DRB Application No.: 04DRB-01380 (FP)
Project Name: SUNDANCE SUBD. UNIT 2
Agent: Isaacson & Arfman PA

Project Number: 1002511
Application Number: 04DRB-01380

**CITY OF ALBUQUERQUE
PLANNING DEPARTMENT
9/22/04 DRB
Comments**

RE: Tract A, Sundance Subdivision, Unit 2/final plat

**EASEMENTS**

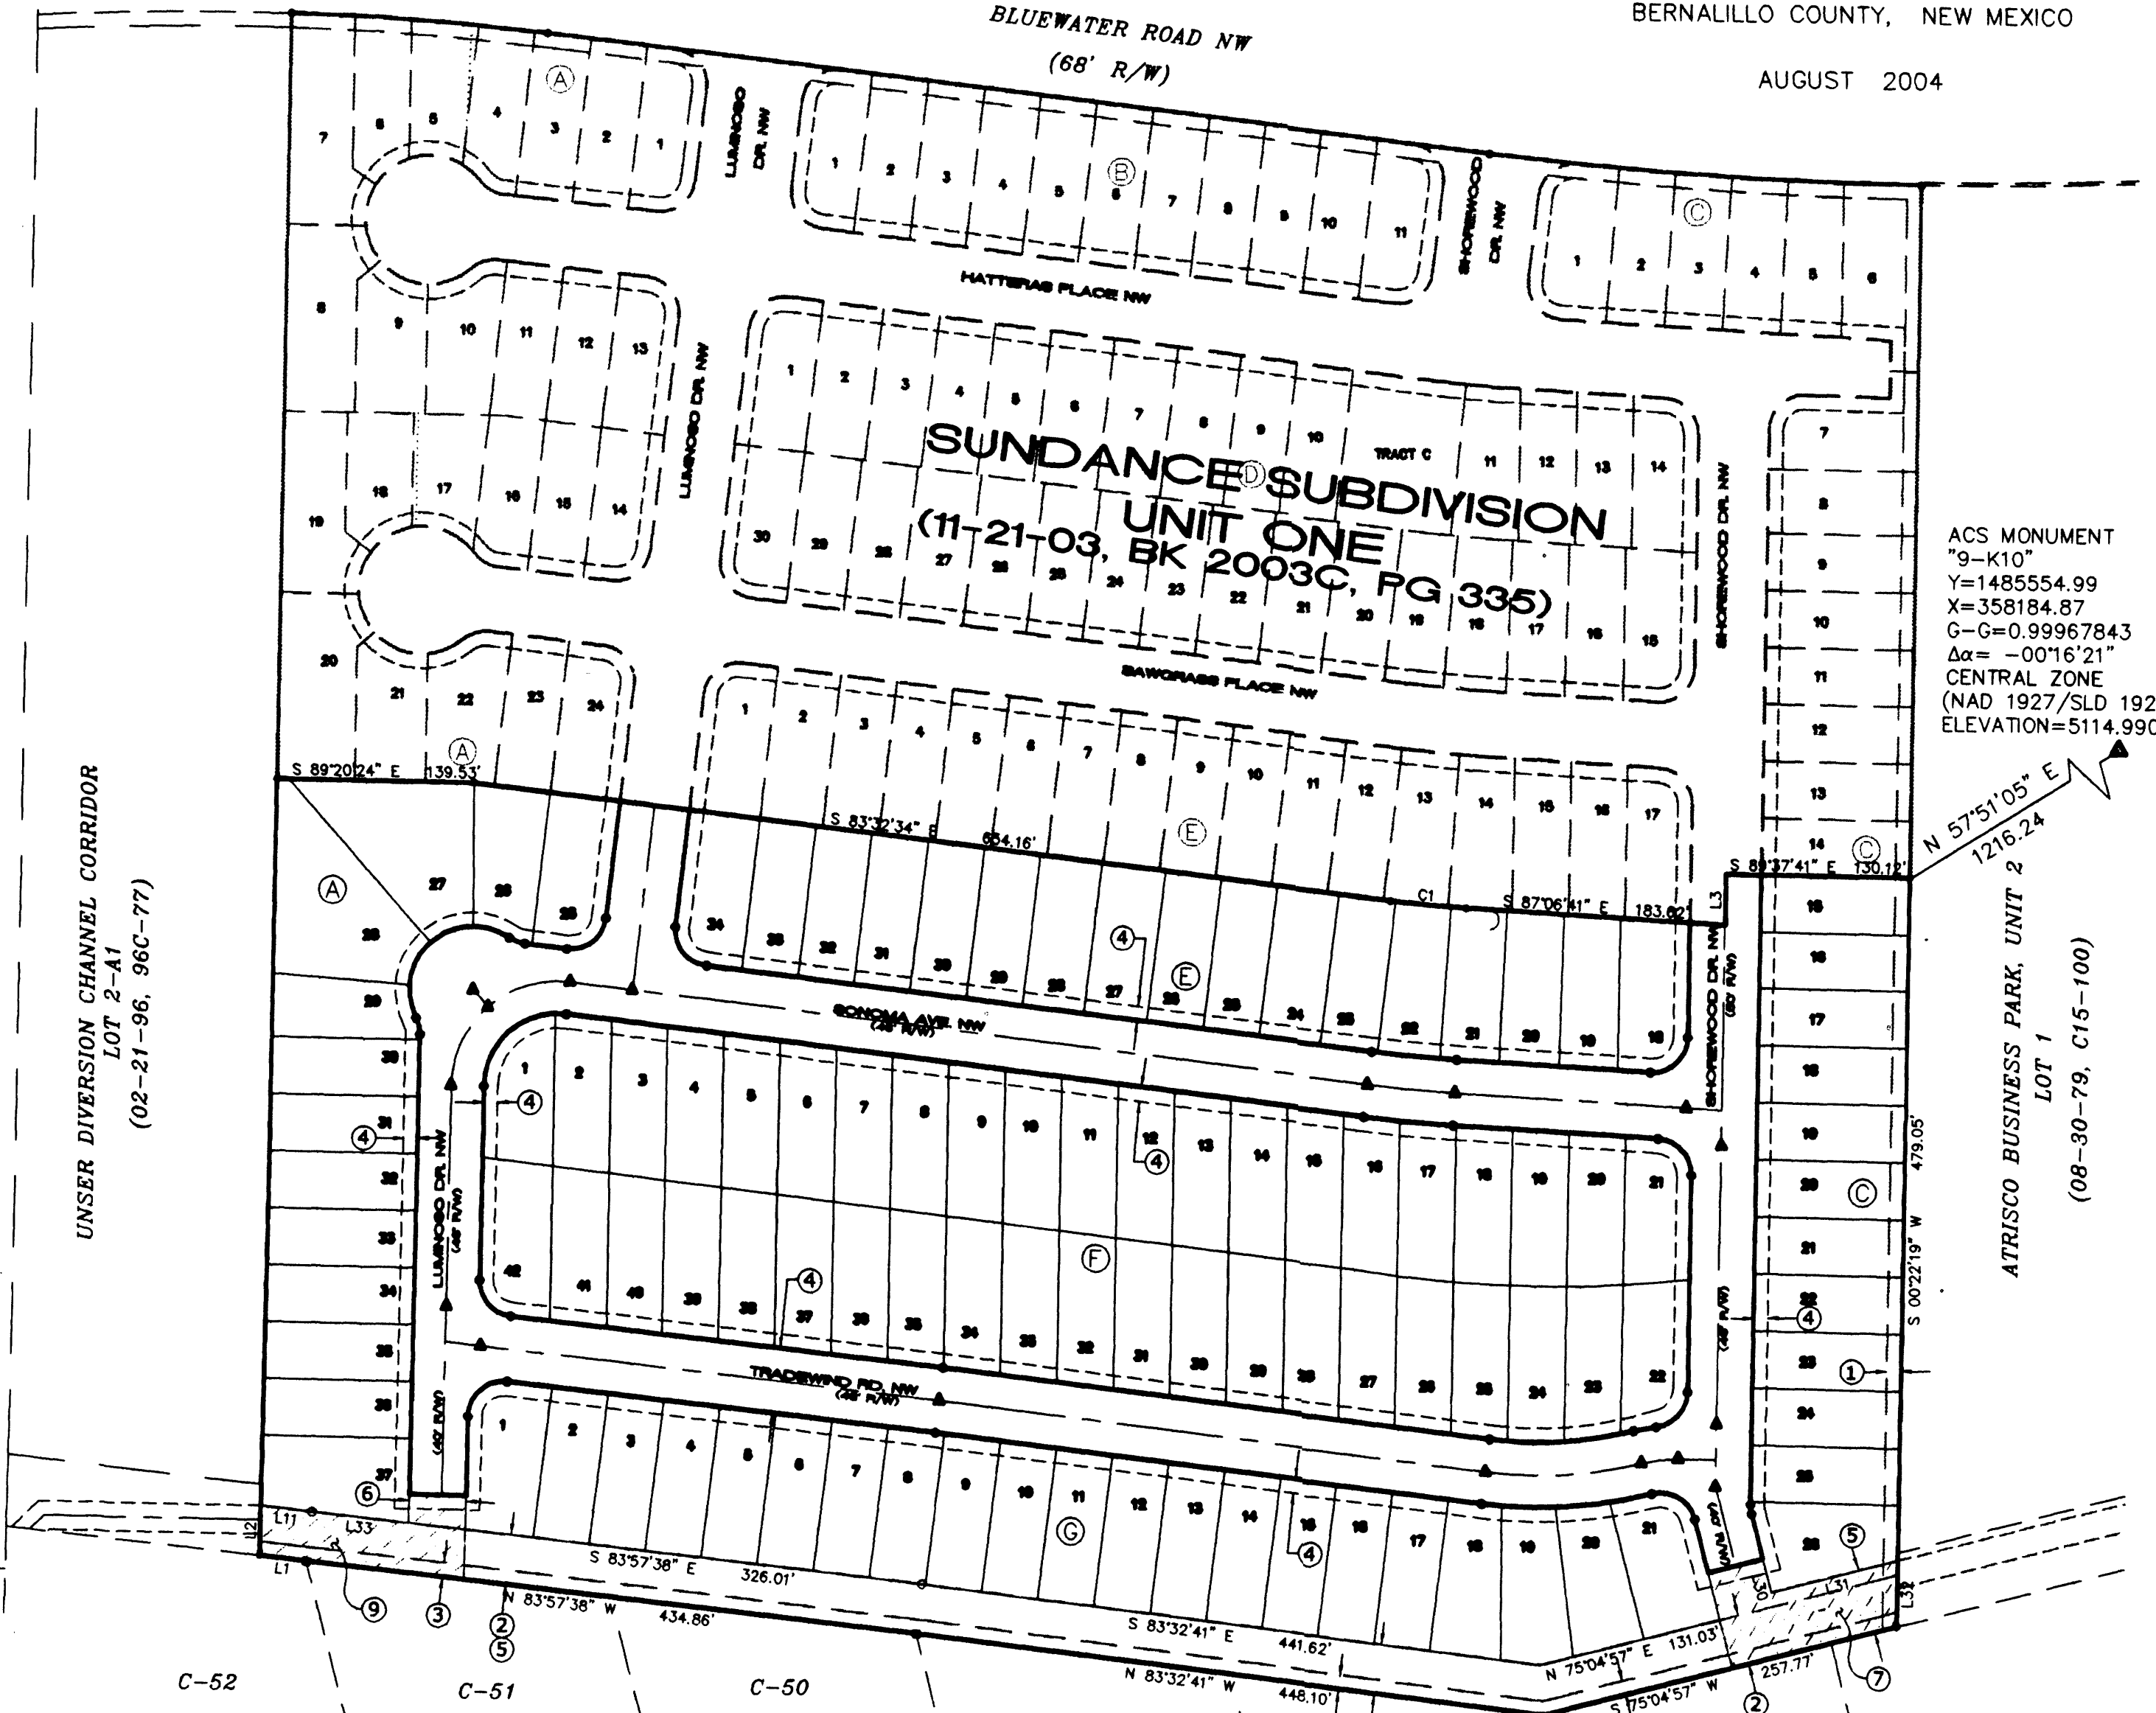
Are there any changes between the preliminary plat approval and this final plat submittal?

No objection to final plat approval provided there are minor if any changes from the approved preliminary plat .

The current zoning should be on the final plat.
